WEST SUSSEX COUNTY COUNCIL CONSULTATION

TO:	Arun District Council FAO: Michael Eastham
FROM:	Stephen Gee, Highways, WSCC
DATE:	15/01/19
LOCATION:	Land east of, Tye Lane, Walberton, Arundel
SUBJECT:	WA/116/18/DOC Approval of details reserved by condition imposed under ref WA/44/17/OUT relating to Condition No 6 Constructiion Management Plan and Condition No 14 construction compound.
DATE OF SITE VISIT:	
RECOMMENDATION:	☐ Advice ☐ Objection ☐ Modification ☐ No Objection ☒ More Information ☐ Refusal
S106 CONTRIBUTION TOTAL:	£ See below for breakdown.

The application is for the discharge of condition 6 and 14 of planning application WA/44/17/OUT for the construction of upto 175 dwellings at Land East of Tye Lane.

Comments below are provided on the discharge of condition 6 – Construction Management Plan.

Client: LINDEN HOMES SOUTHERN				
Project Title: LAND EAST OF TYE LANE, WALBERTON				
Drawing Title: PROPOSED CONSTRUCTION PHASING PLAN				
A1 Scale 1:1000	Date NOV 2018	Designed by KI		
Drawn by KI	Checked by AP	Approved by KM		
Drawing Number 183240-008				Rev D

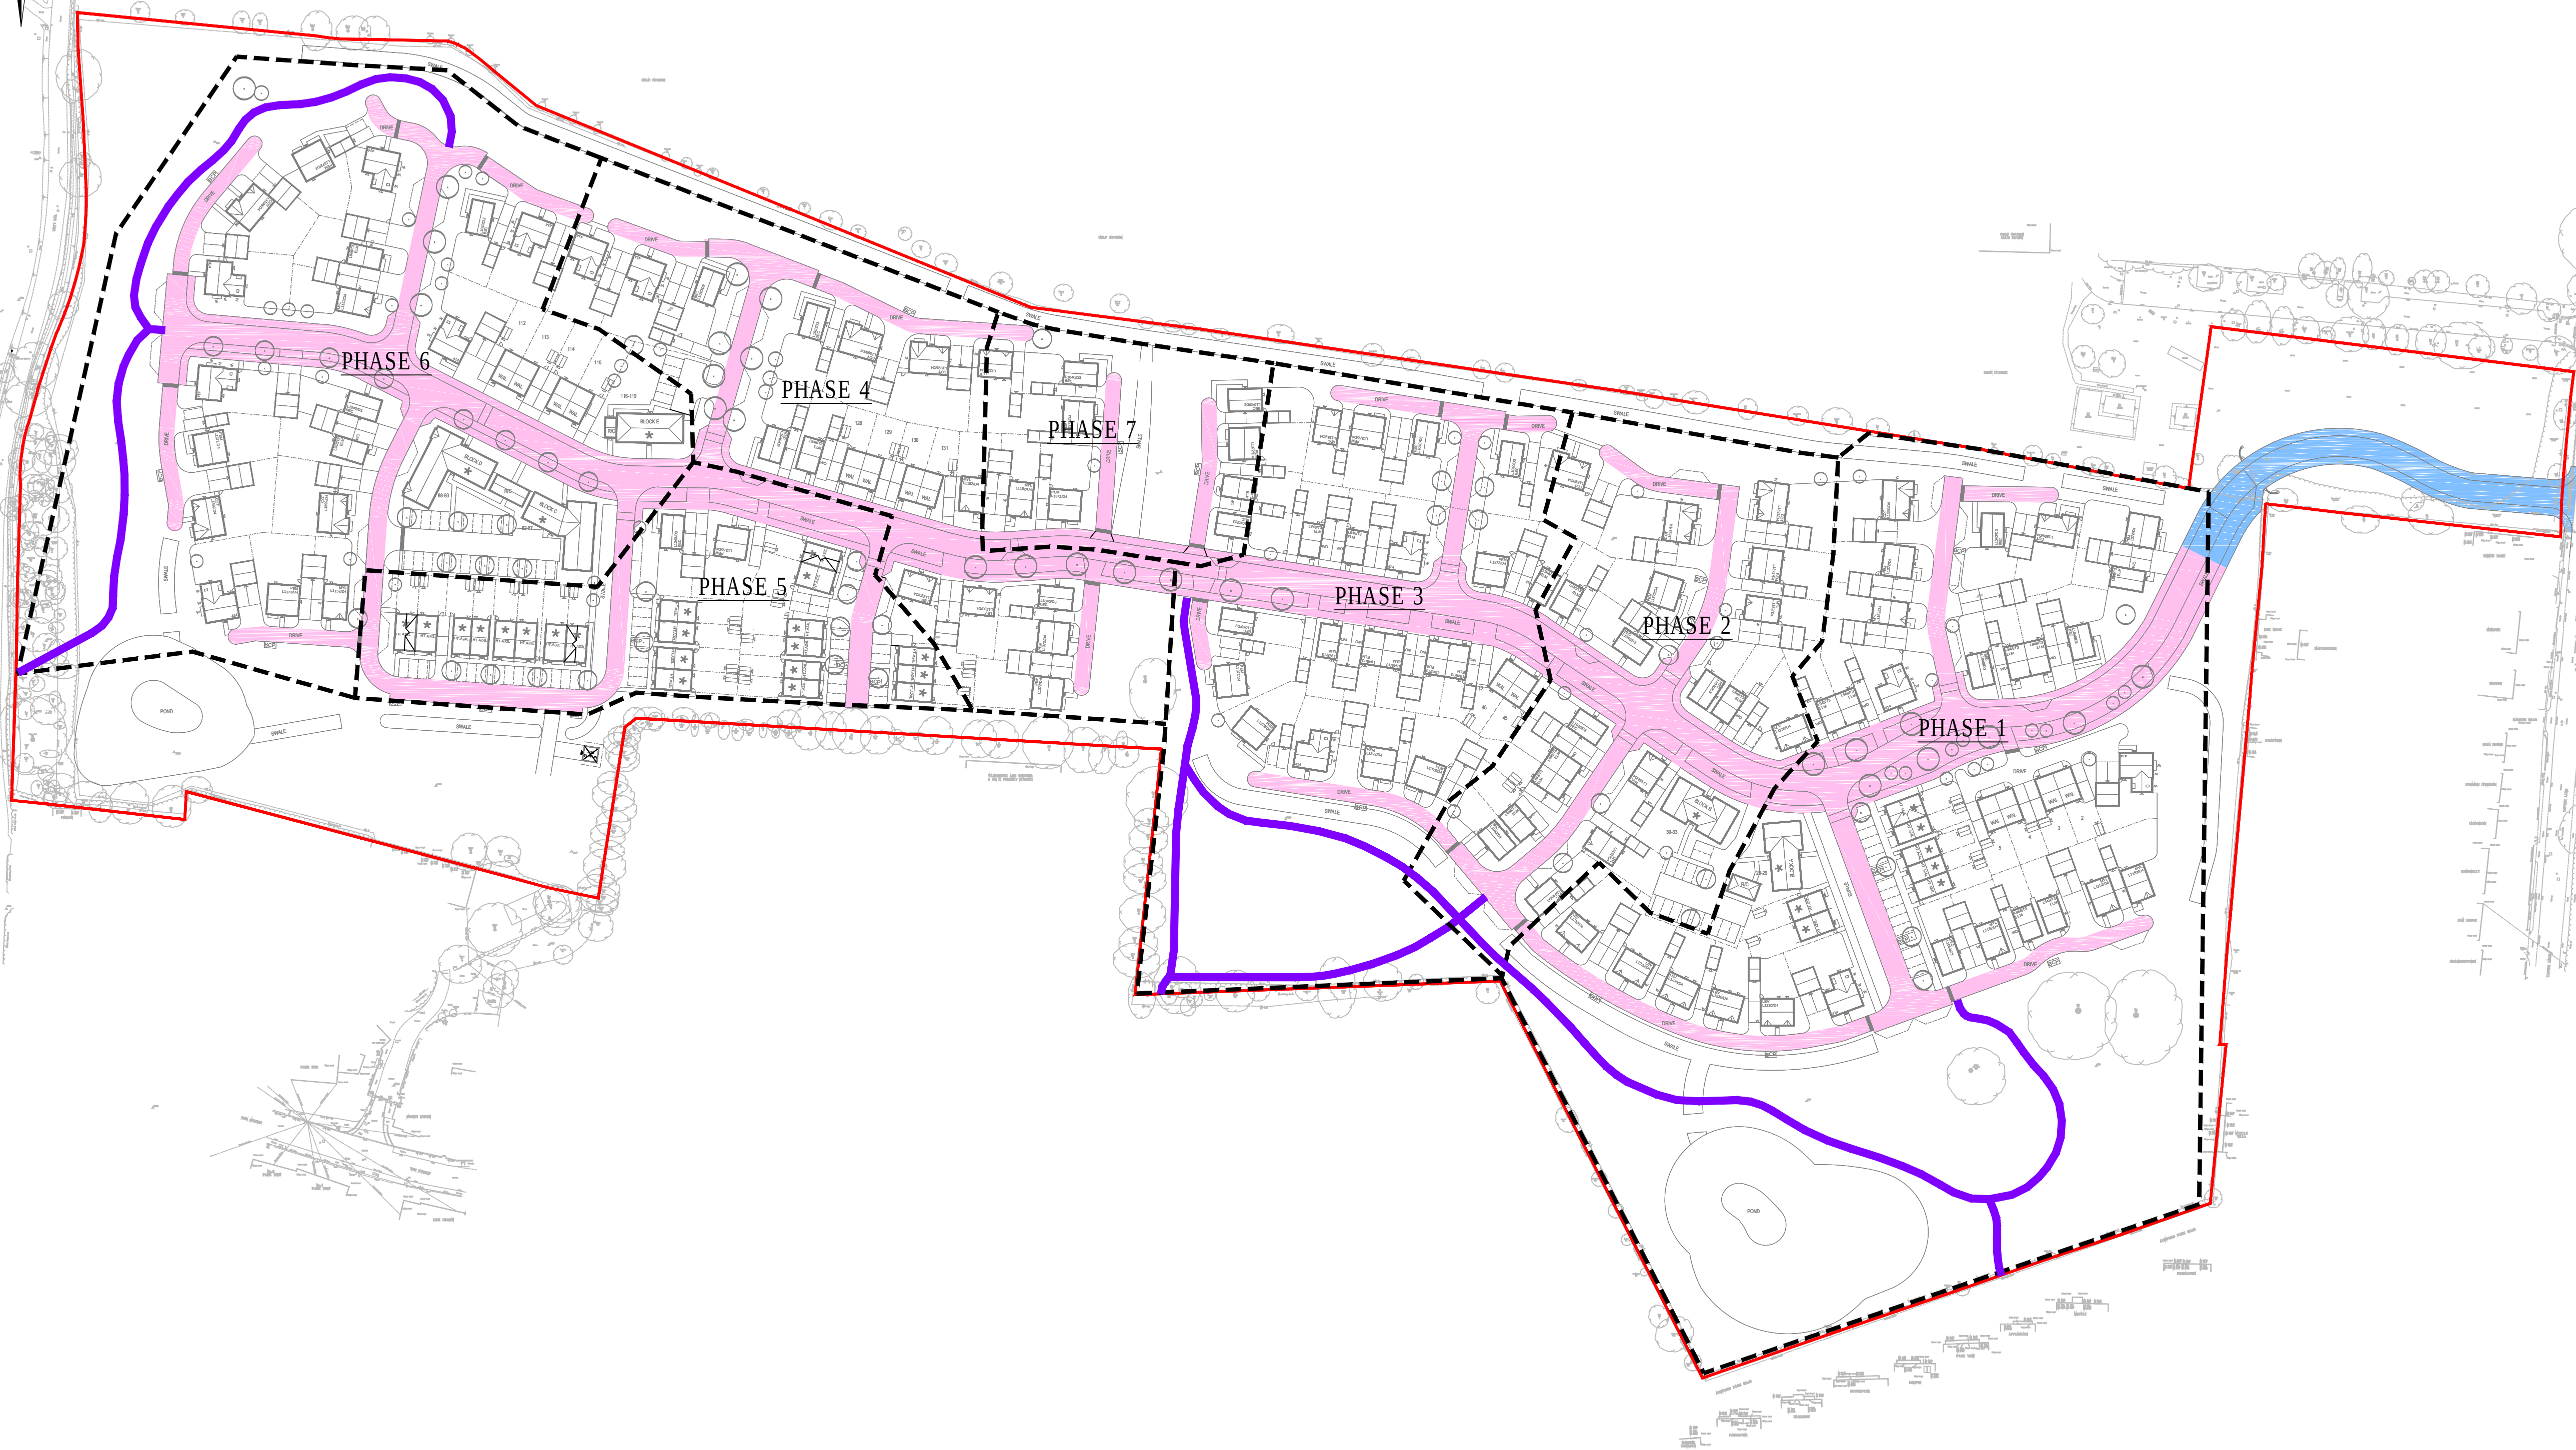
Phasing plan – additional information is required on the pedestrian and cycle links to be provided. At present the plan only details the highway construction and as such only shows a pedestrian link at the site access. This would result in longer pedestrian trips to key facilities in the locality and result in car borne habits being engrained in residents from first occupation.
